## DEVIATION REVIEW AND DECISION FORM

Subdivision or Project Name: The Reserve at Corral Bluffs Subdivision Filing No. 2

Section of ECM from Which Deviation is Sought: Section 2.3.8.A. Cul-de-Sacs

Specific Criteria from Which a Deviation is Sought: Maximum Length of Rural Cul-de-Sac

Figure 1
**Deviation
 Exhibit**

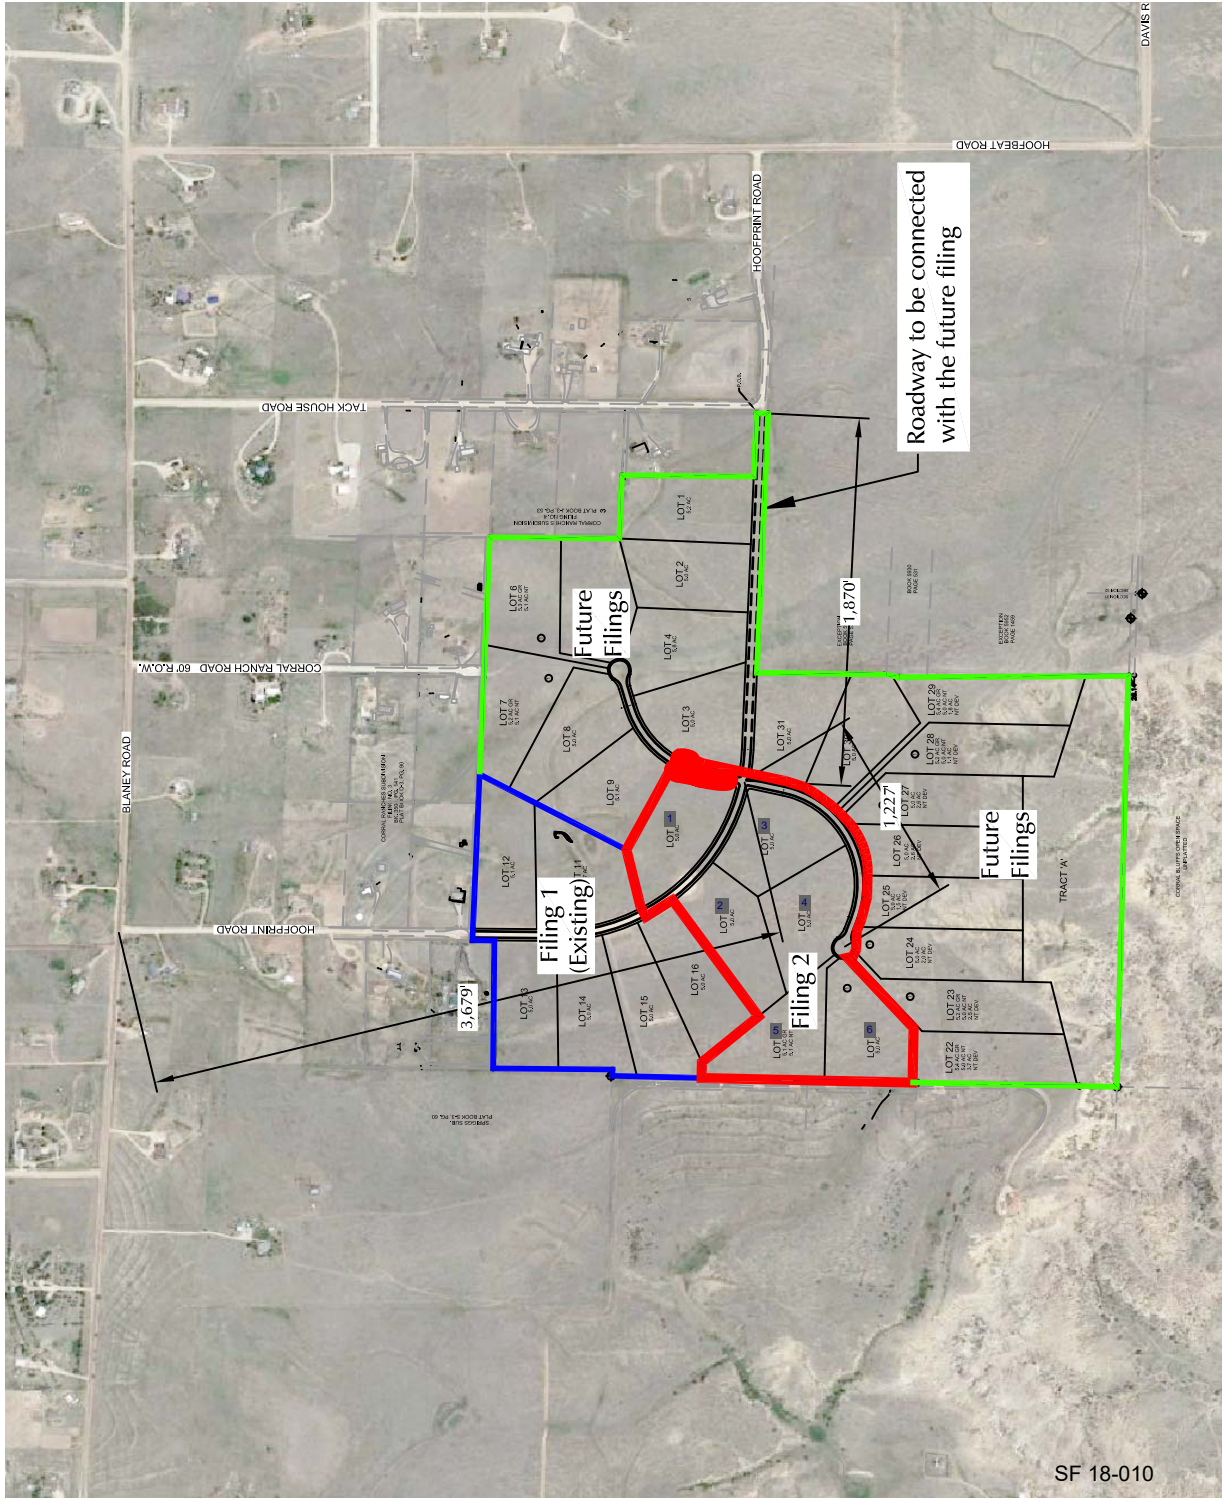
1. Include an exhibit.
2. Include a written endorsement from the Fire District per ECM 2.3.8.A.
